2014/442 Spicer Hill Wind Farm Extension

Ecology Addendum

This addendum is in response to comments received from the Biodiversity Team at Barnsley Metropolitan Borough Council on 6th January 2015. The comments refer to the Environmental Statement submitted for planning application 2014/1442, Spicer Hill Wind Farm Application.

Figure 6.1 – Bat survey transects and stopping points

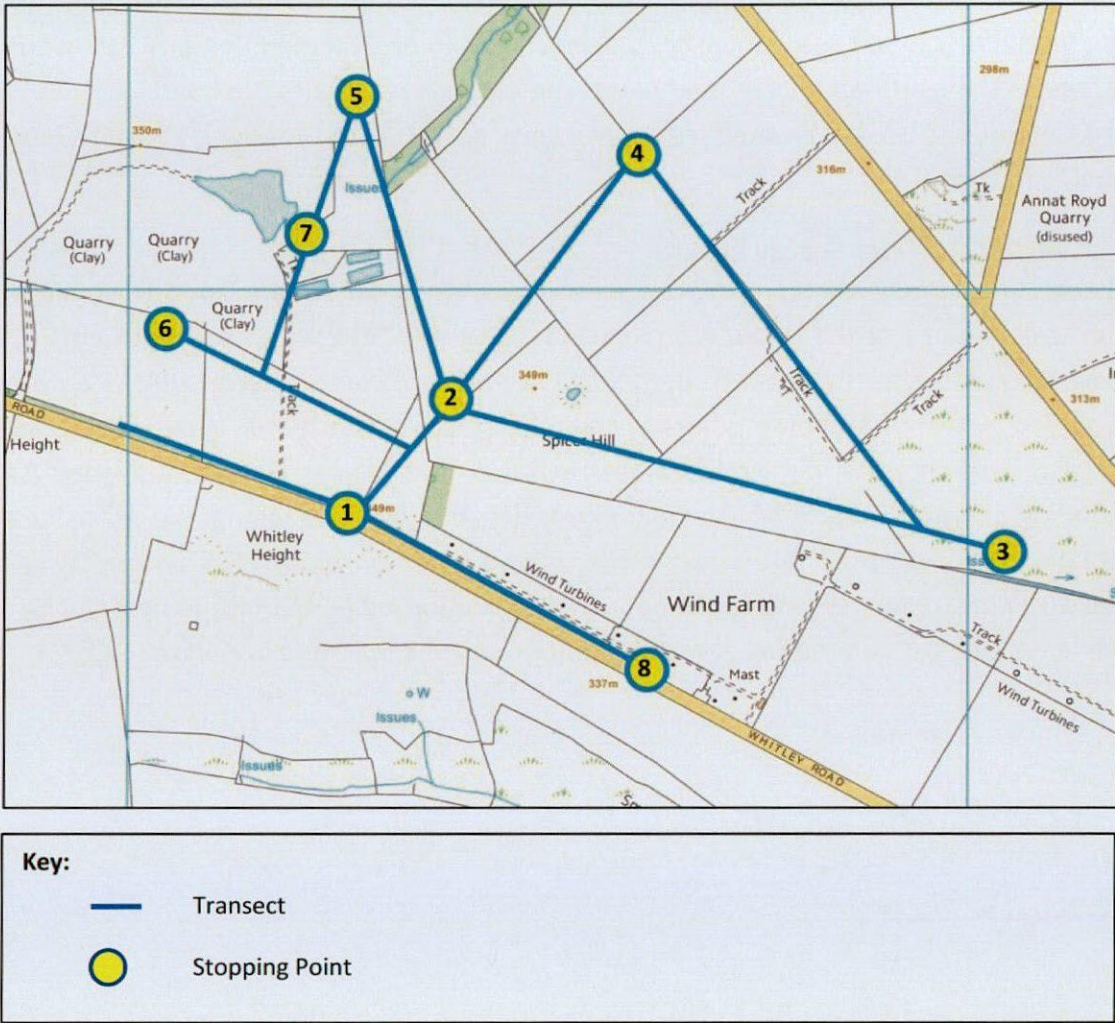
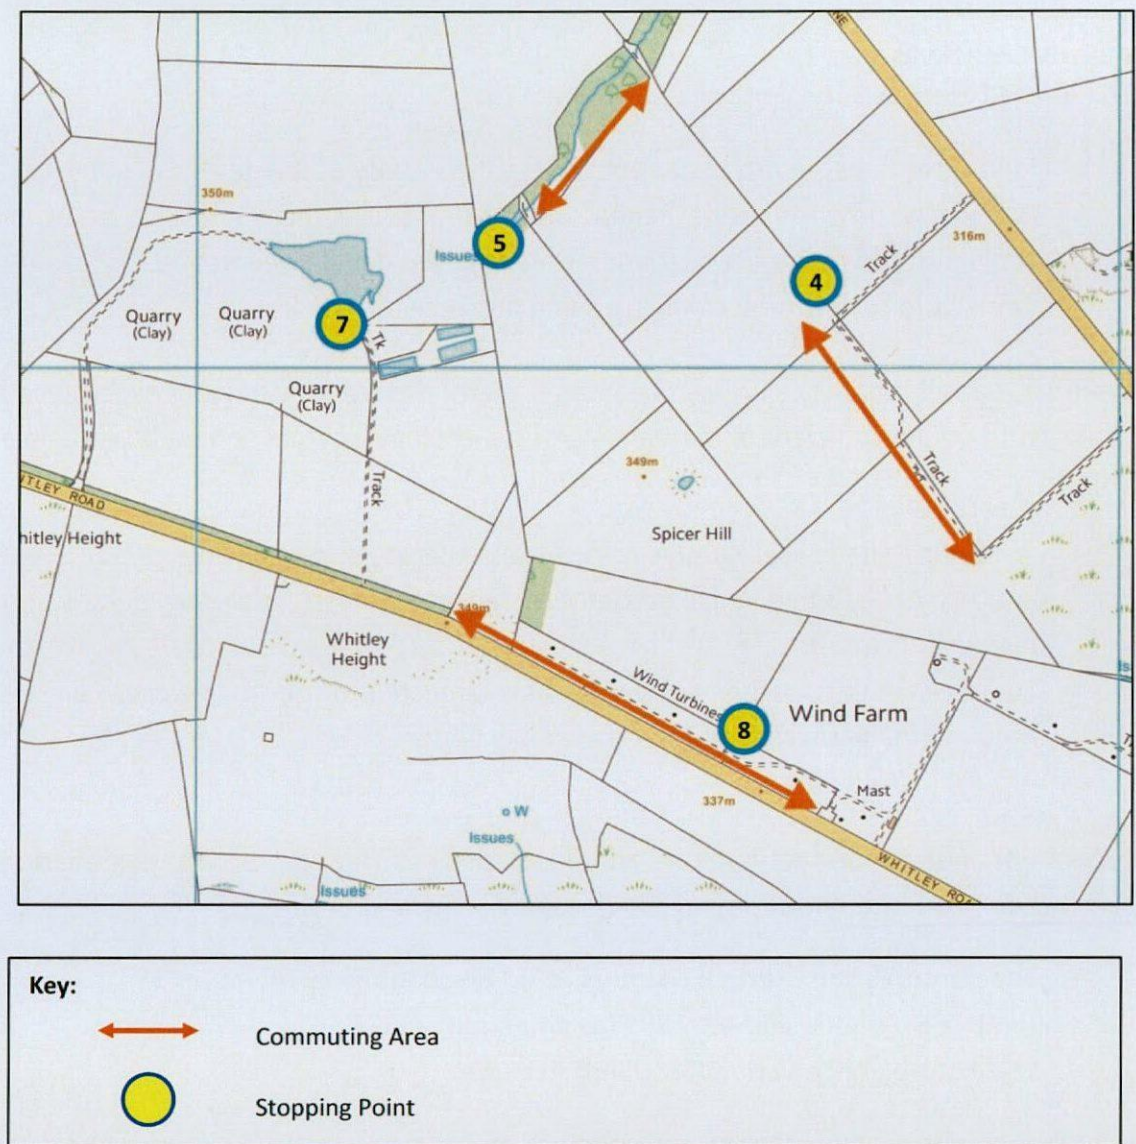
1.4 *s6.6.7 notes that other data shows bats present within 5km of the site but not how close – this really ought to be detailed more fully to enable the reader to understand the significance.*

Bat data was supplied by South Yorkshire Bat Group within a 5km radius of Spicer Hill (file attached). In total there were 147 records relating to 5 definite species (common pipistrelle, soprano pipistrelle, noctule, natterers bat and brown long eared bat). The great majority of the records were quite distant from Spicer Hill at Penistone, Thurlstone, Gunthwaite, Hazelhead, New Mill, Hepworth. The nearest and only relevant records to Spicer Hill were a single common pipistrelle and a noctule recorded at Royd Moor. The nearest records apart from those at Royd Moor were at Penistone.

Document Title:
Proposed Habitat Enhancement

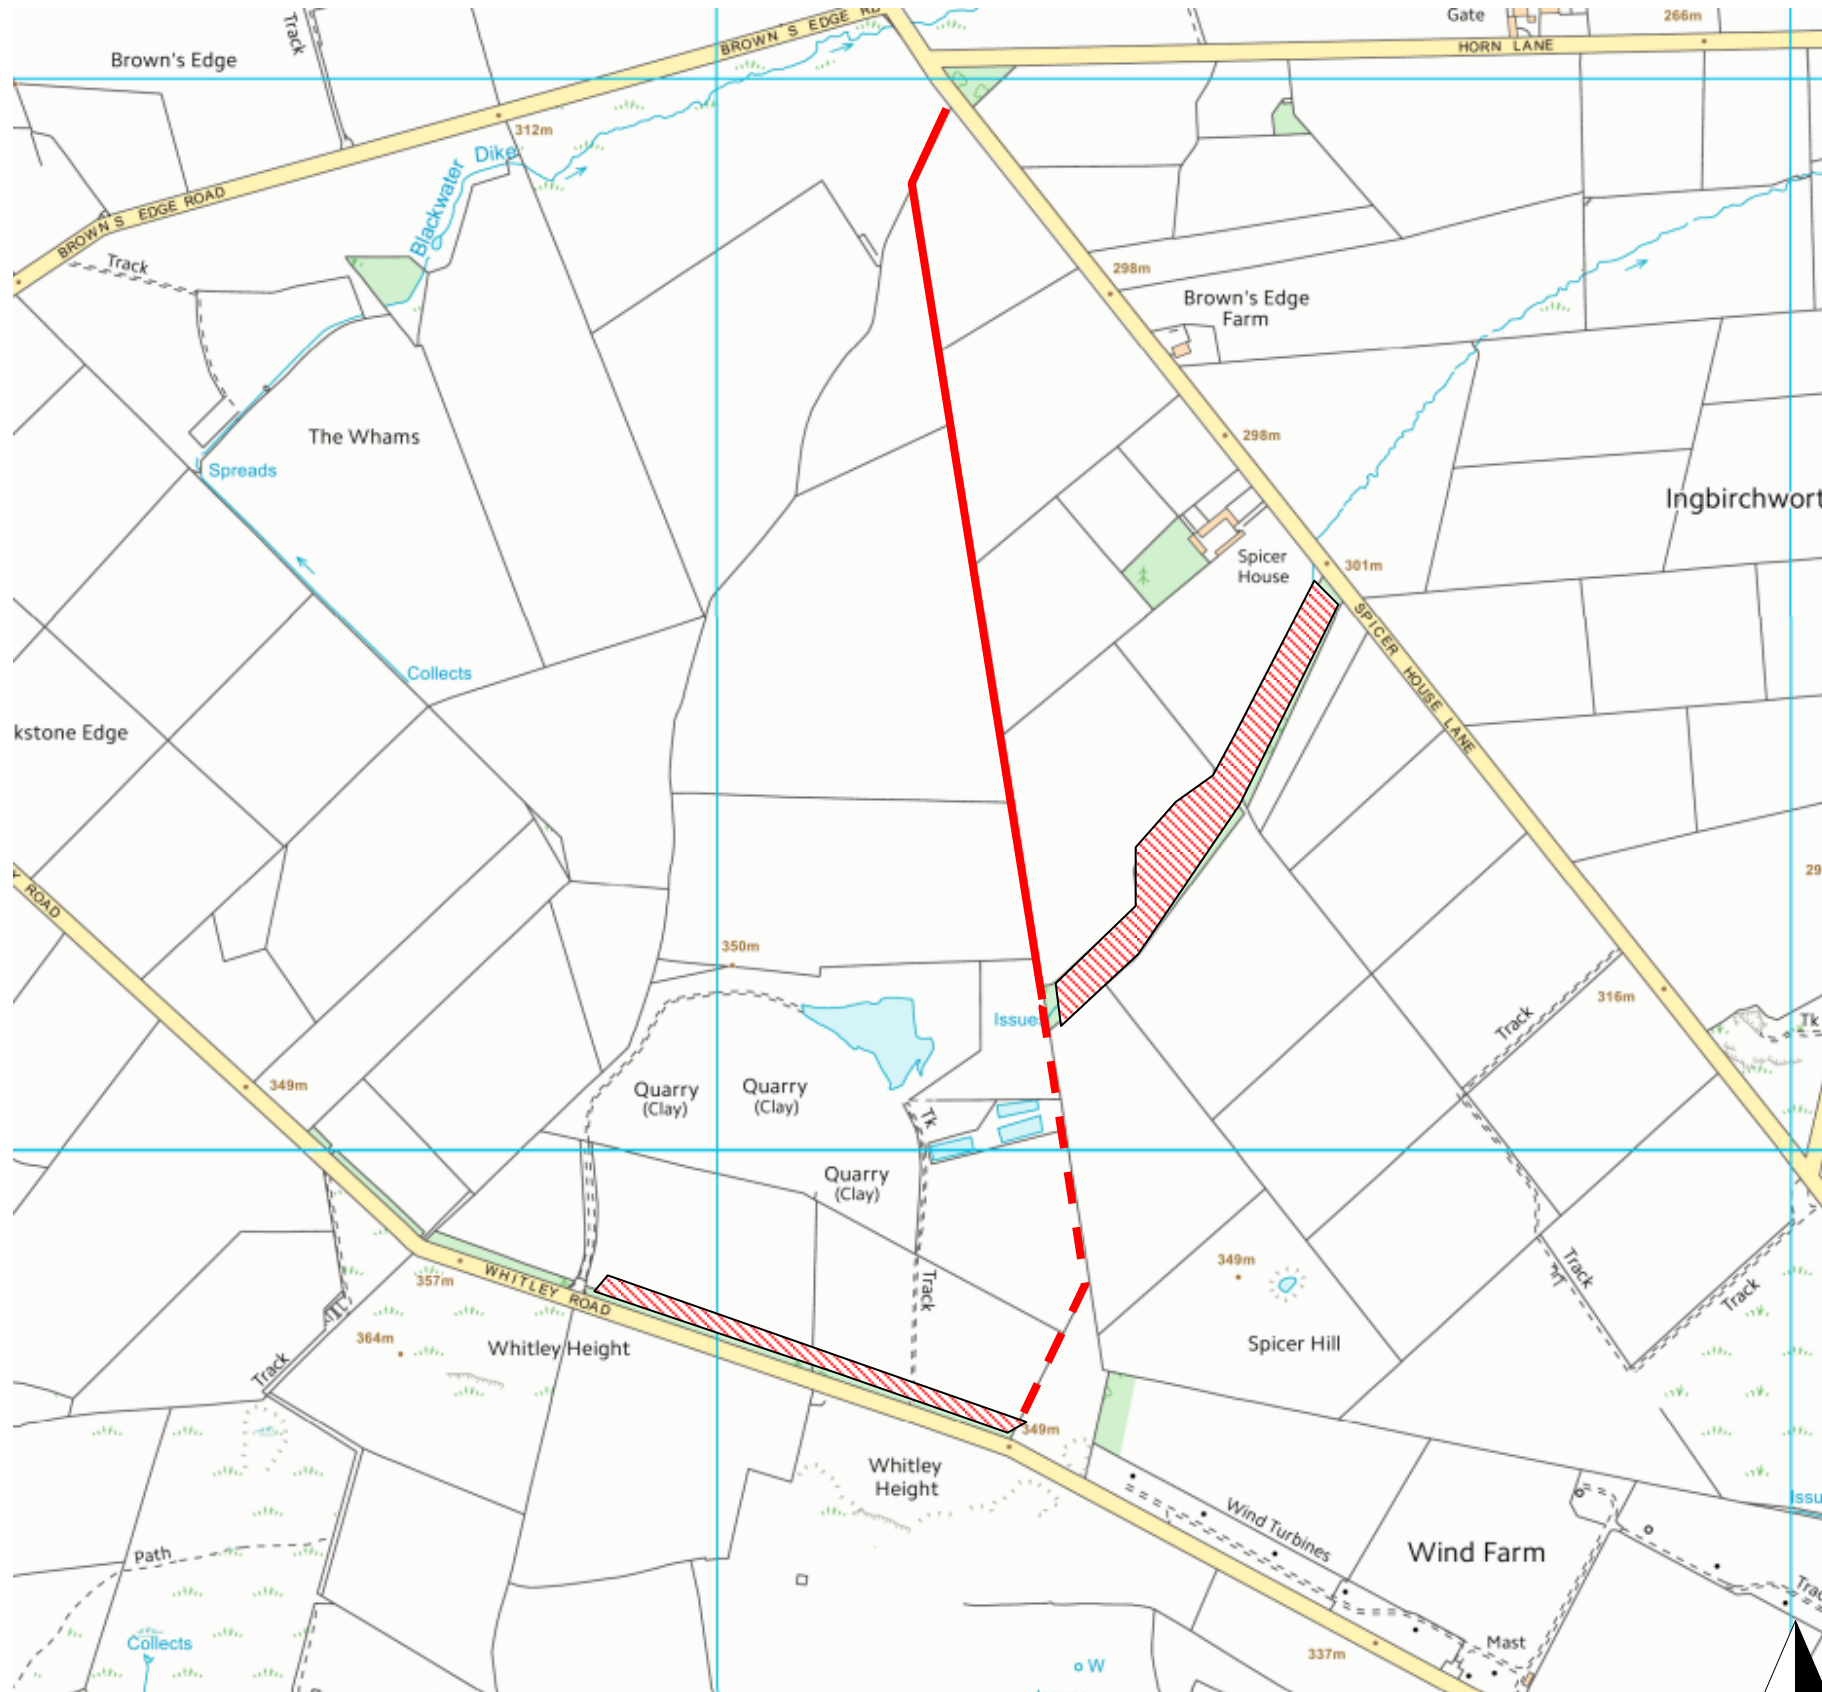
1.7 *As for breeding birds, I do not accept regarding s6.7.5 that no mitigation is needed at all for bats.*

1.8 *I would suggest that the applicant proposes biodiversity mitigation for damage and losses of habitat, which also benefits bats and breeding birds. For example, ecological improvements to some grassland habitat somewhere on the application site. This need not be exhaustive as it only needs to be proportionate to the small losses that are possible. But it should be detailed in a way that could be conditioned.*

It is considered that as described in 1.8 proposals for habitat enhancement would be beneficial for bats and birds in providing linear pathways and feeding corridors. It is also considered that a minimum of twelve bat boxes be erected on suitable trees adjacent to Whitley Road and in trees adjacent to the Blackwater Dyke that runs north-west towards Spicer House Lane. The hedgerows and linear pathways as planned in 1.8 would then connect the roost areas with the quarry, the vegetated stream that runs from

the centre of the site to Spicer House Lane and also suitable foraging areas to the north. These measures are shown in the attached plan.

It is proposed to erect bat boxes along the wooded area adjacent to Whitley Road and in trees adjacent to the Blackwater Dyke that runs north-west towards Spicer House Lane.

From the western edge of this wood it is proposed to plant 850m of hedgerow with native species e.g. native hawthorn and alder. This would head north past the quarry edge then eventually reach Spicer House Lane. This would create linear pathways for bats leading them to foraging areas at the quarry and also to the Blackwater Dyke and beyond. The hedgerows would also create shelter, nesting sites and foraging habitats for a variety of bird species.

These measures are shown in the attached plan.
